Please can this plan be treated as a substitute supplementary plan and the agent's e-mailed scanned for info?

sorry I have been pointed out that should have renamed the Comparative Site drawing attached in the previous email, from '1917-PL-150A Proposed Site Layout (Comparative Layout)' to '1917-PL-155 Proposed Site Layout (Comparative Layout)'.

Please find attached the amended site plan in which I have overlapped previous approved application's layout and the new proposed site layout for comparison and to look at the House Type 3 in relation to the boundaries.

COMPARATIVE
ELEVATIONS

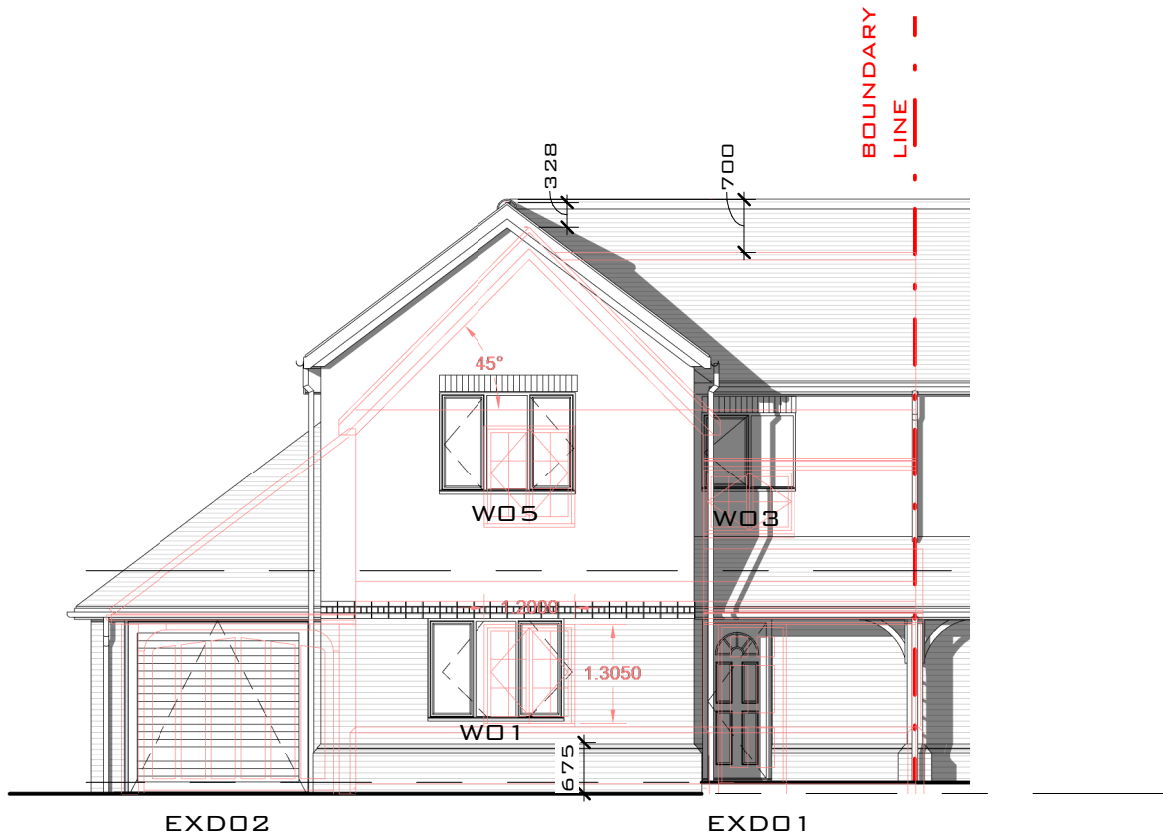
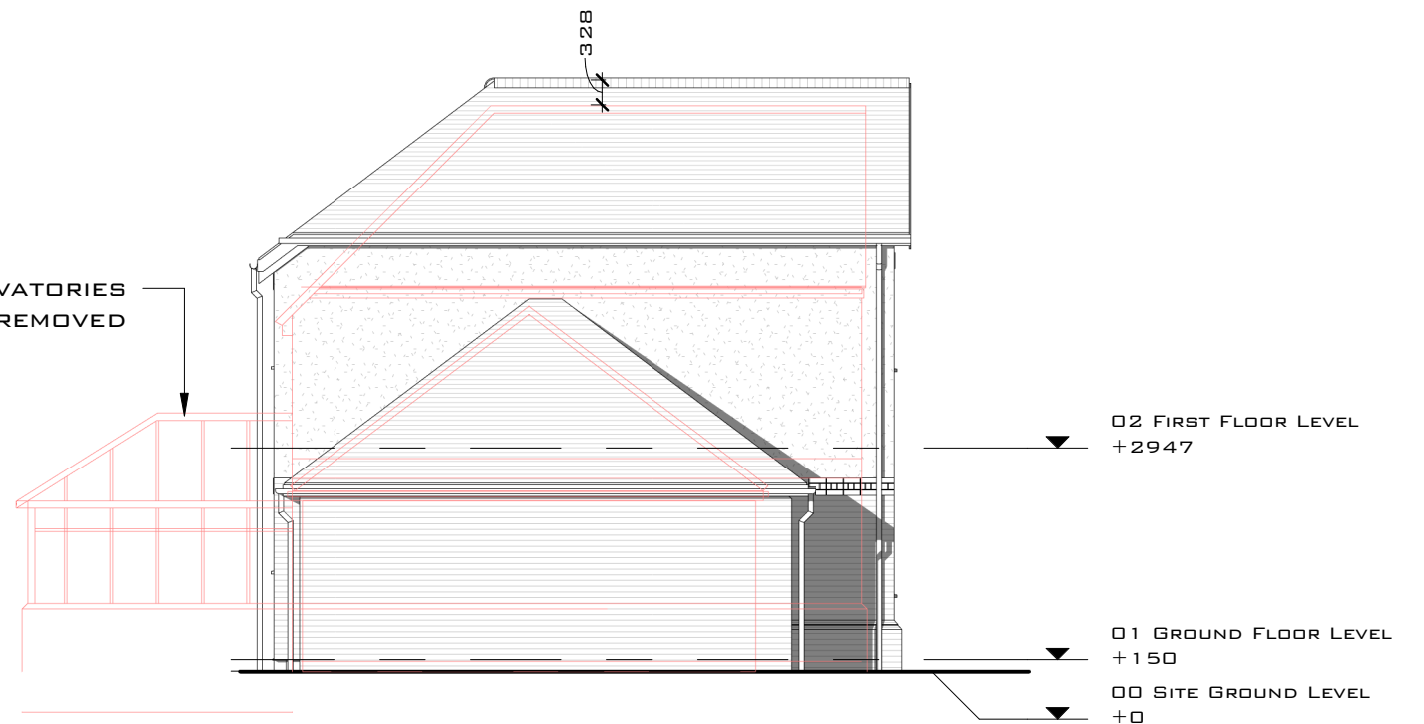
I have received the above application today. In order to progress your application promptly I would appreciate clarification of the changes to the footprint of the dwelling proposed. At the moment I am unable to print plans and scaling from the website is not very accurate. Please can you confirm which plots numbers are affected (I assume it is plots 5 and 6), details of the differences in ridge height (this appears to be 0.7m higher) and dwelling width (appears to be 0.7m wider) and a comparative layout plan of the approved dwelling in relation to the plot boundaries. It looks as though plot 6 is now positioned on the boundary and has been moved towards the rear of the site.

I have also attached an overlapped elevation drawing to show the ridge height increase.
